SUBJECT: Engineering Review Comment
Mountain View Electric Association Inc. (MVEA)

Project Name: Foundation Lutheran Church – Tract C, Paint Brush Hills F13A
Project Number: SF2321
Description: Proposed development of a commercial lot/church on approximately 6 acres located at Towner Ave and Londonderry Dr. in Township 12S, Range 65W, Section 25.

SUBDIVISION PLAT
FOUNDATION LUTHERAN CHURCH
SUBDIVISION FILING NO. 1

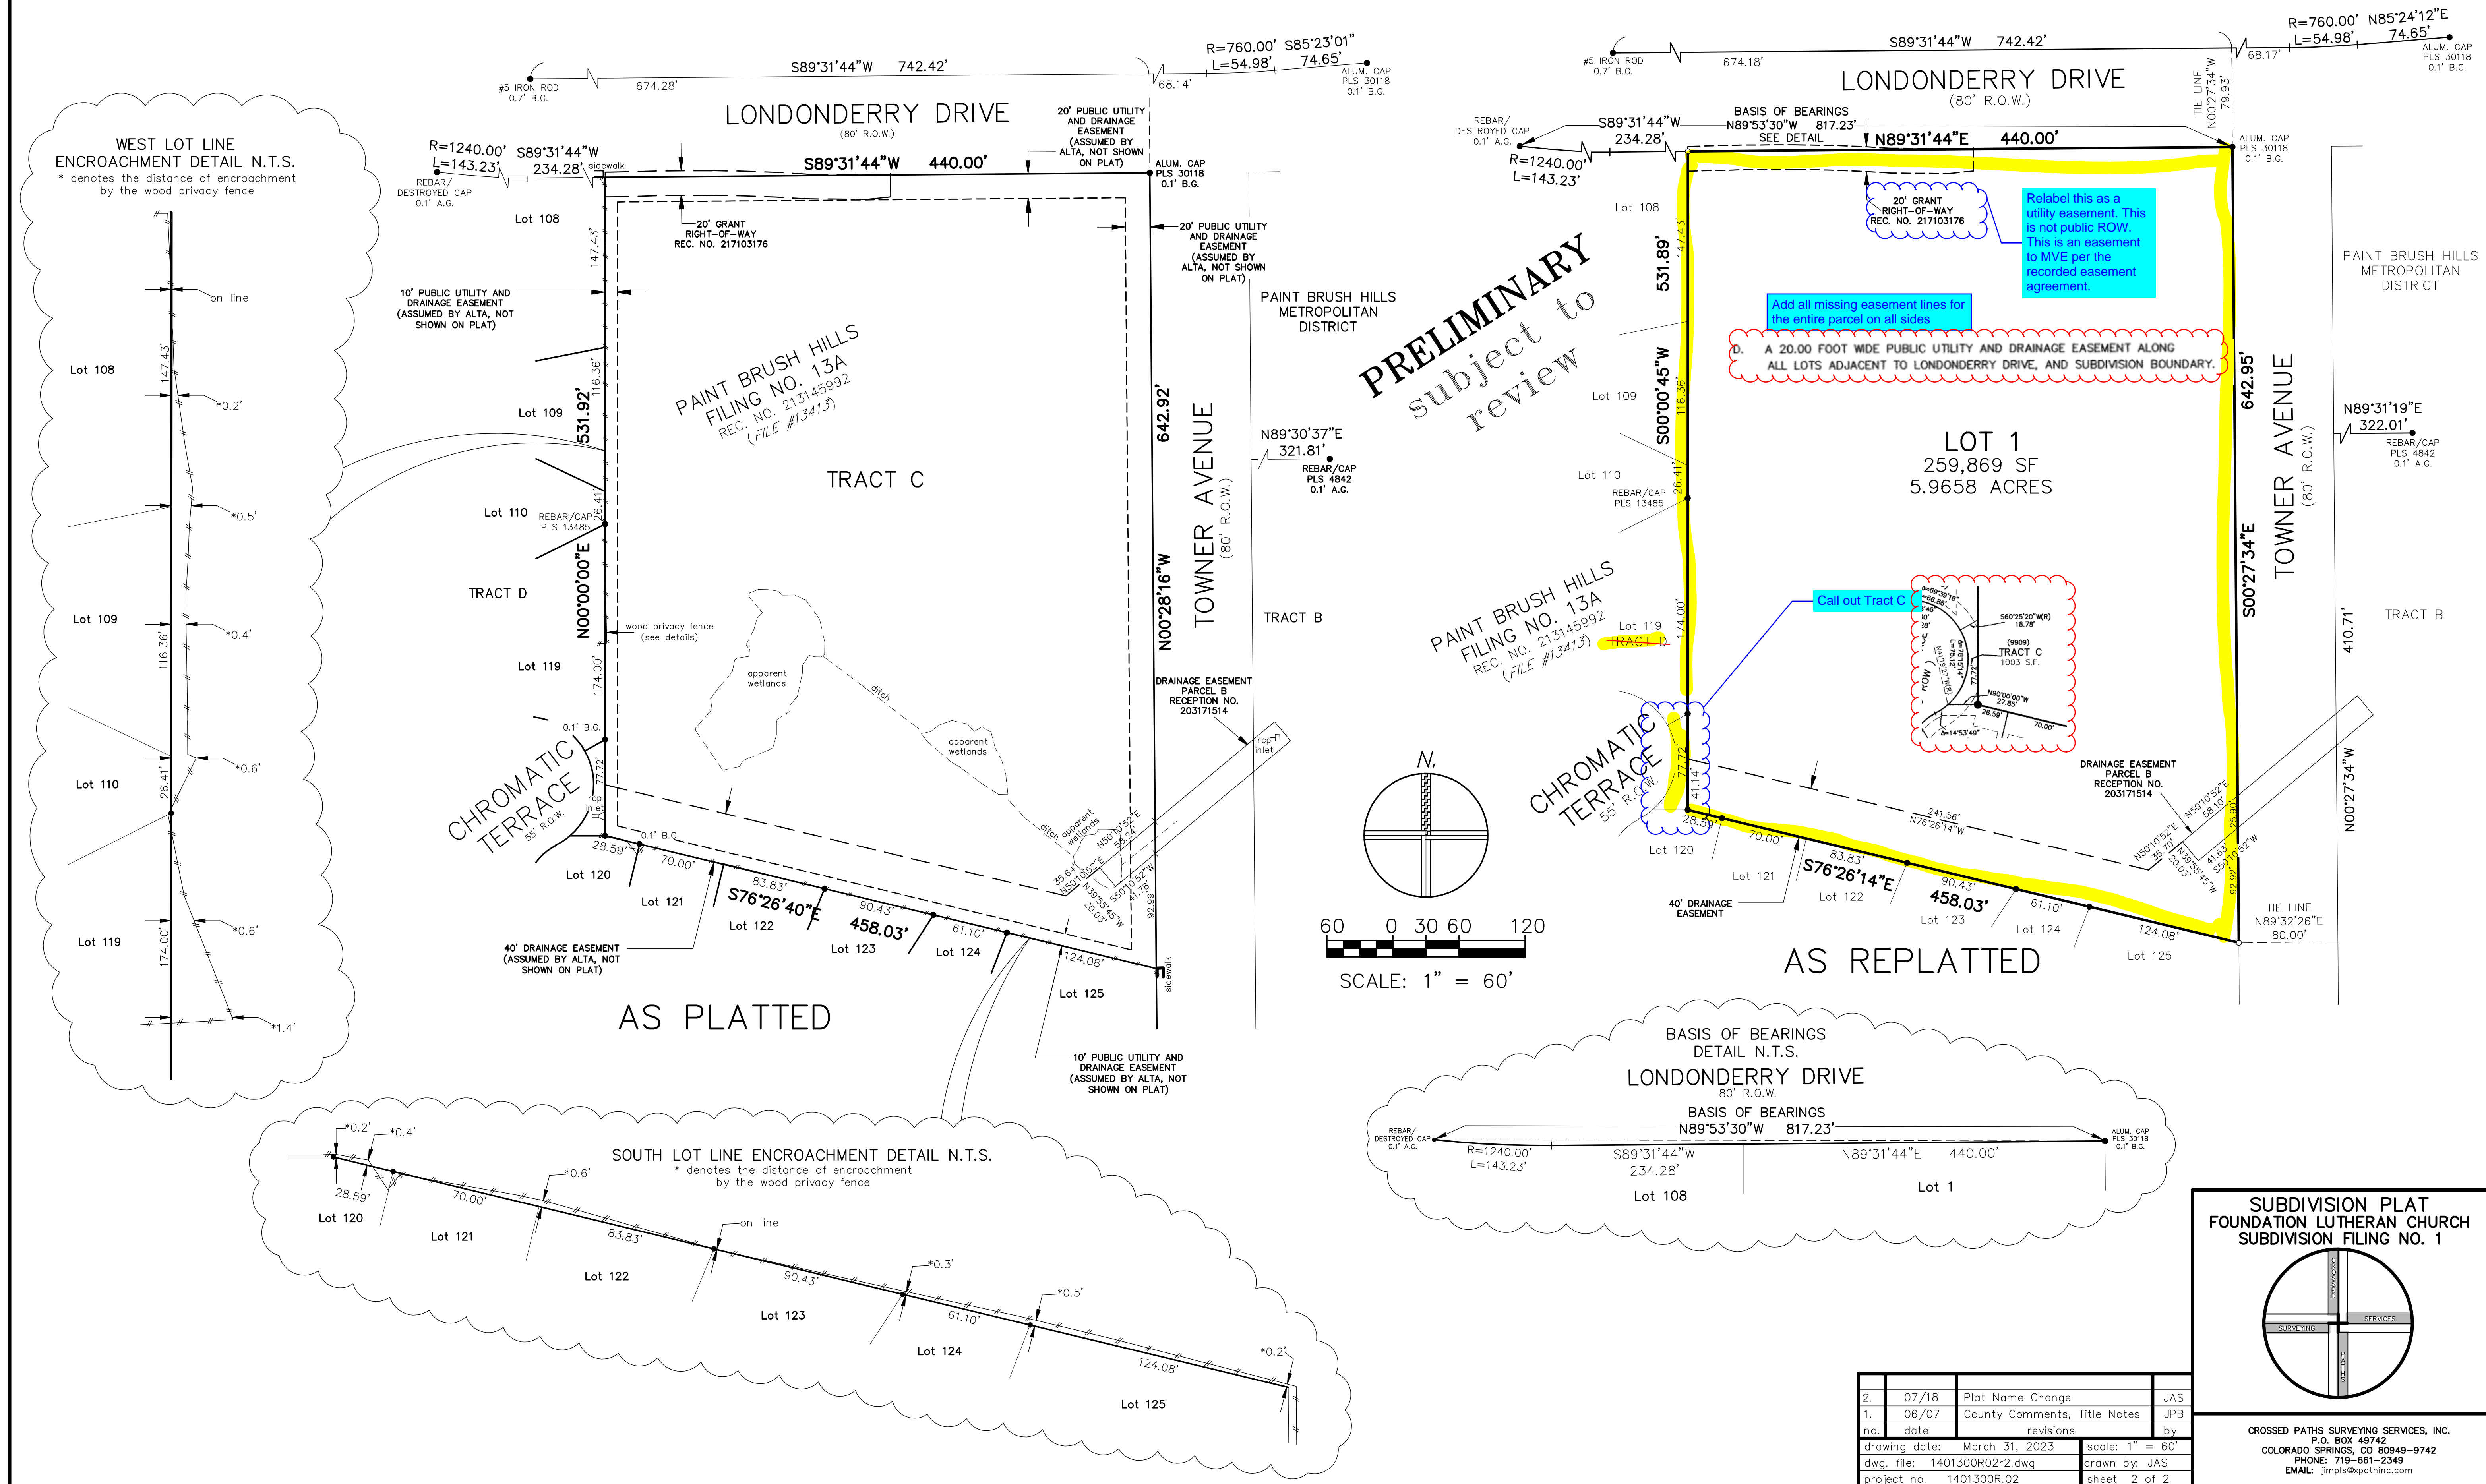
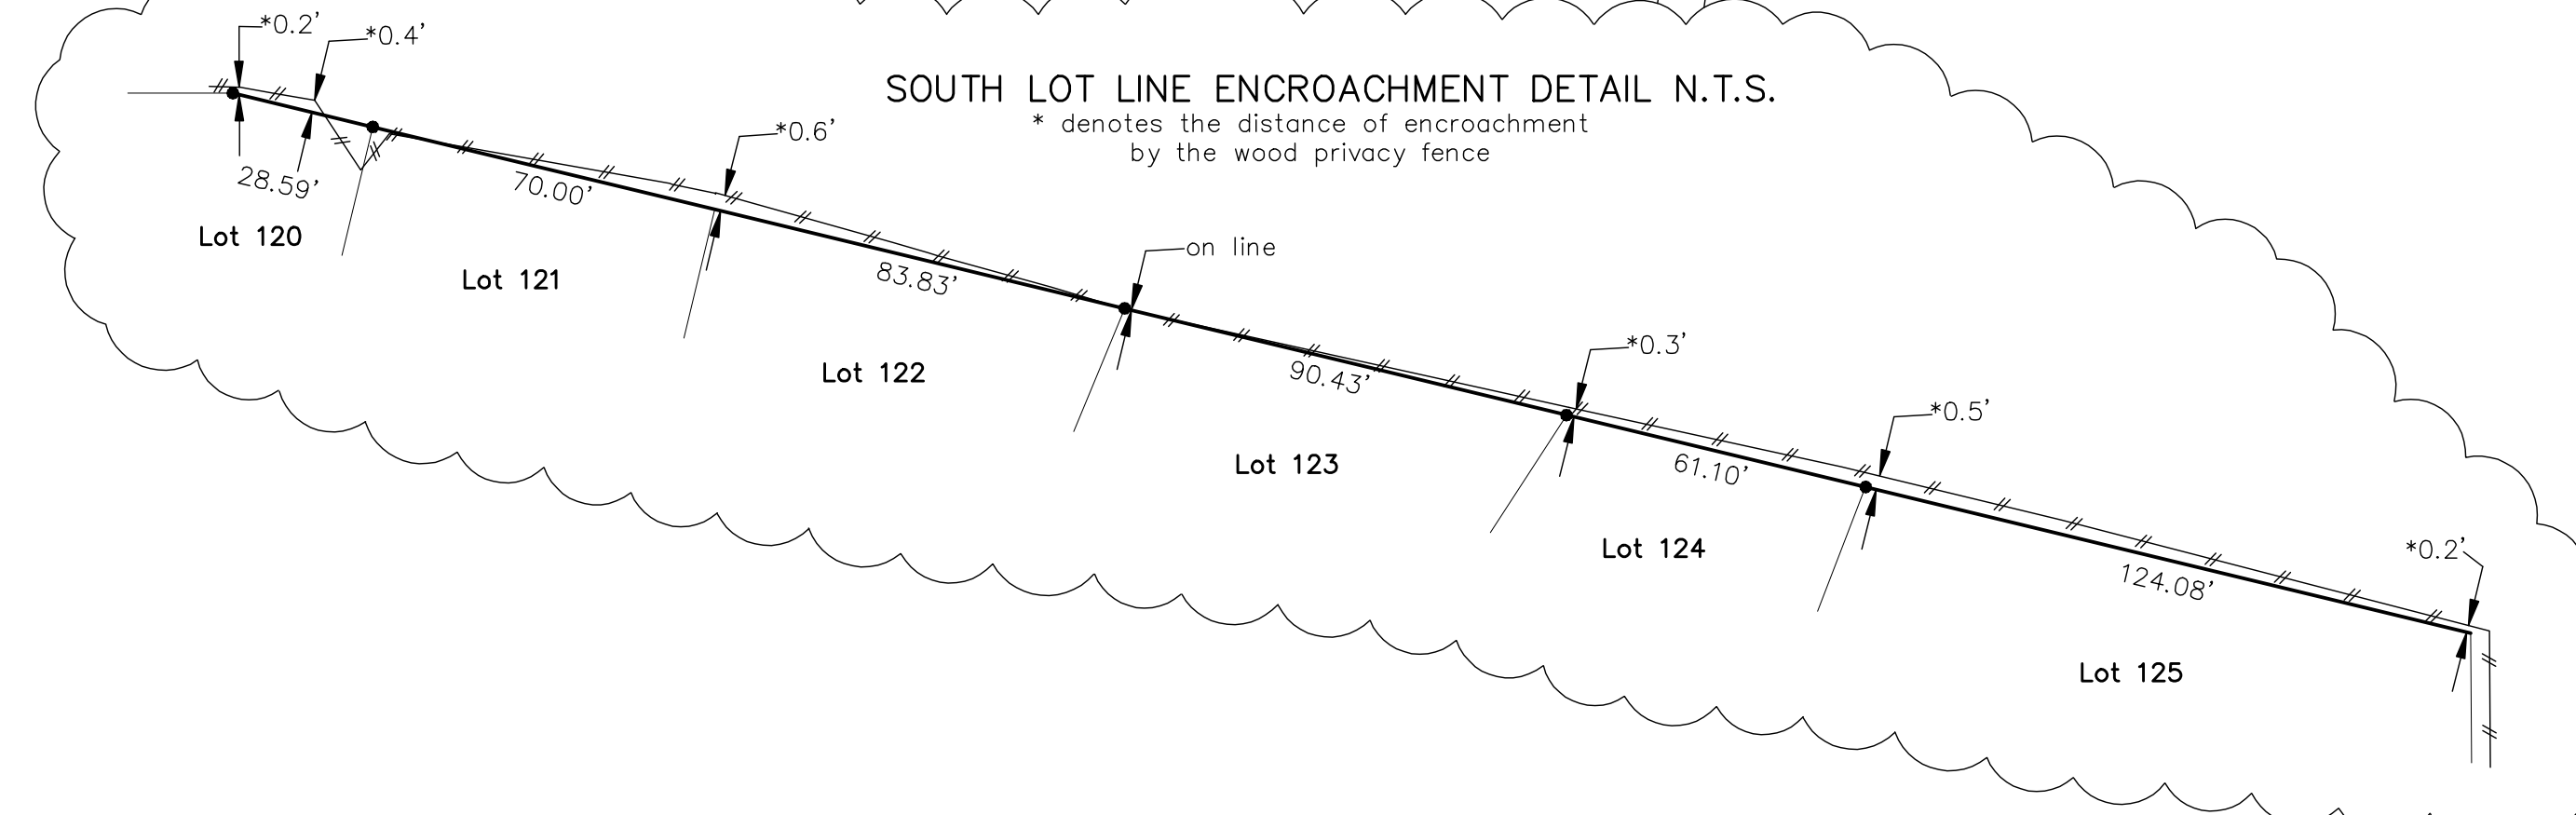
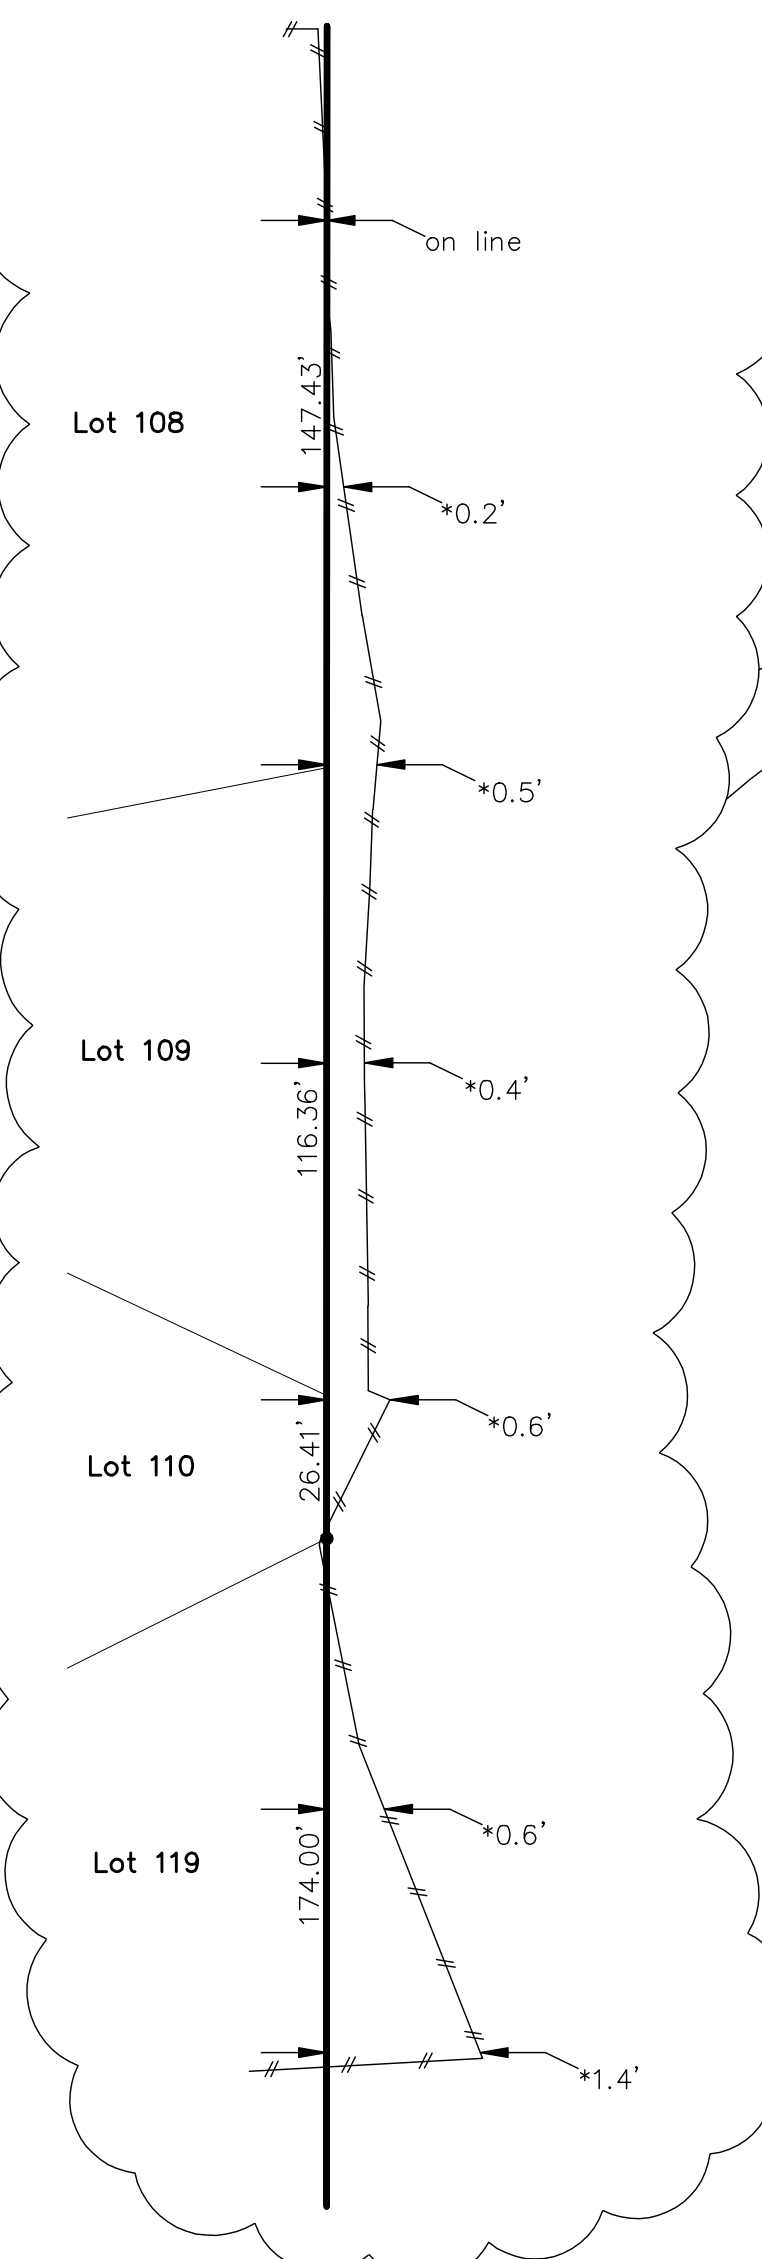
MVEA requests twenty (20) foot front, side, and rear utility easements/exterior boundary on commercial lots and will work with the developer on the design of the electric service and to acquire any additional easements. MVEA also requests the platting of MVEA's existing facilities with easements on the plat.
